MECKLENBURG COUNTY  
Park and Recreation Department

MEMORANDUM

**RE:** Rezoning Petition #2022-200  
PID# 04711207

SCHEMATIC SITE PLAN

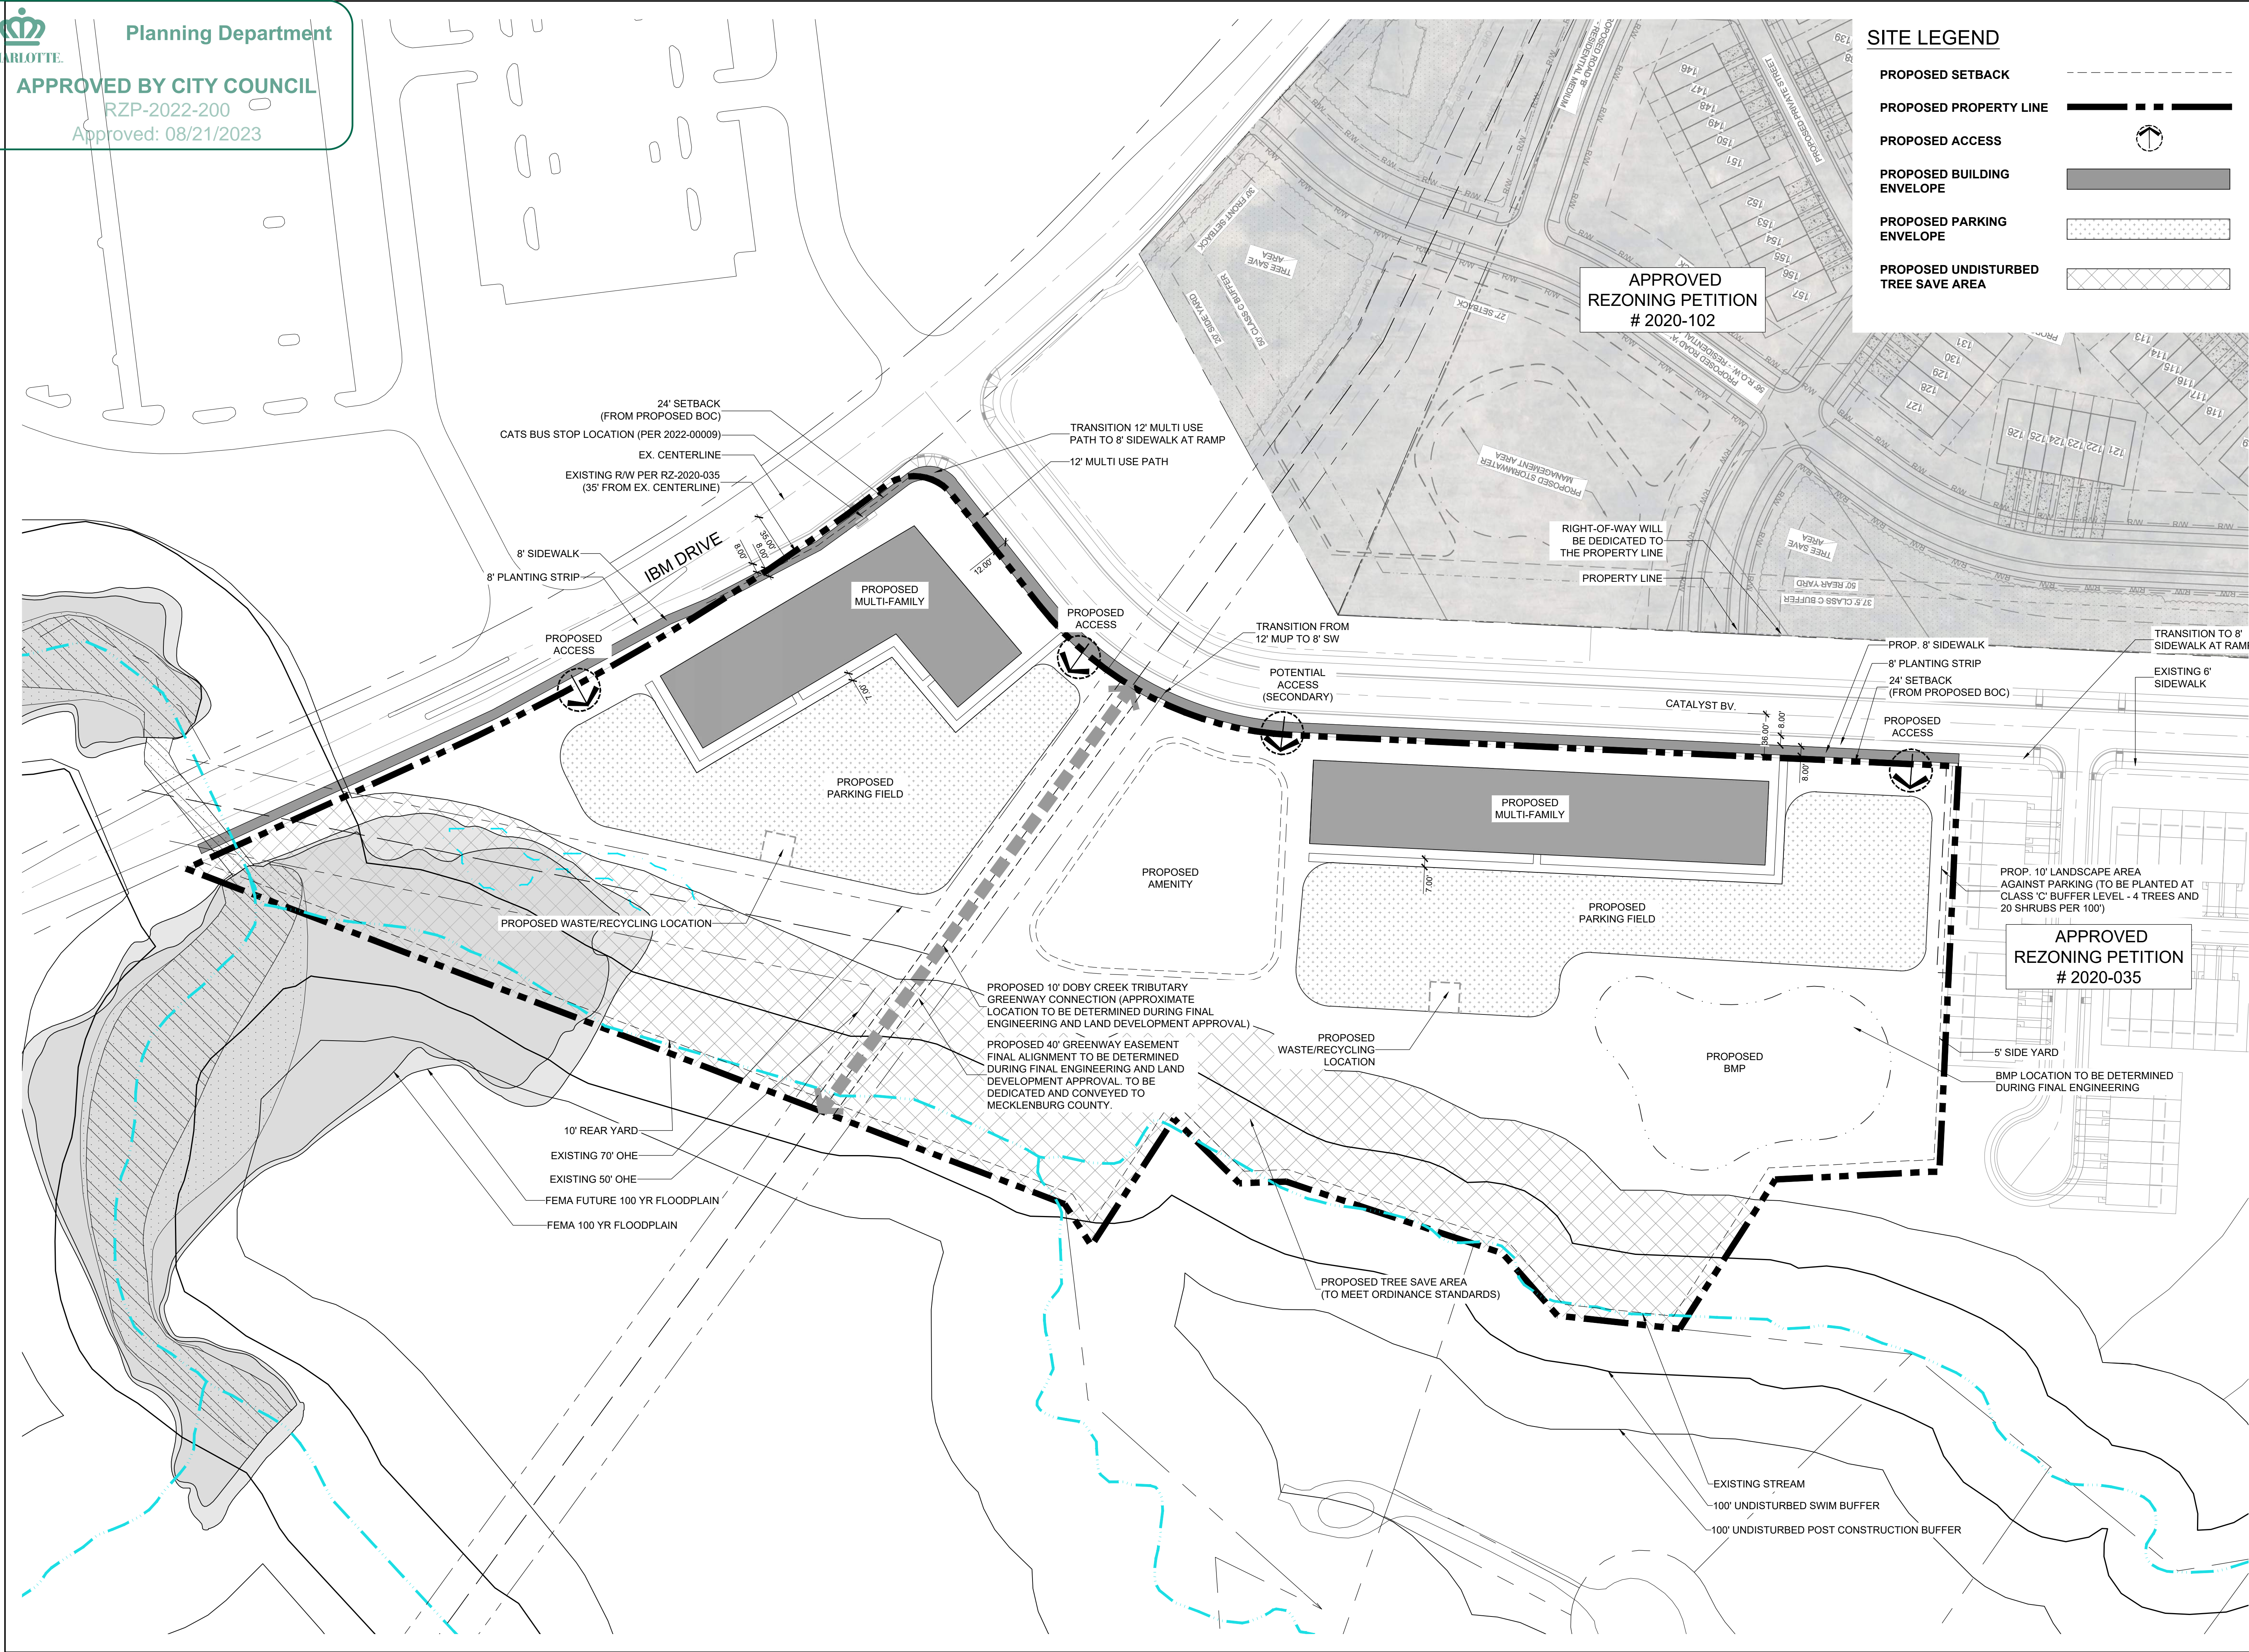
Please show a 12 foot wide multi-use path along Catalyst Bv. from Doby Creek Greenway up to the intersection with IBM Drive.

Please show an easement over Doby Creek Greenway that is in the old rail corridor the width of that original rail right of way to be dedicated and conveyed to Mecklenburg County prior to the issuance of the first CO.
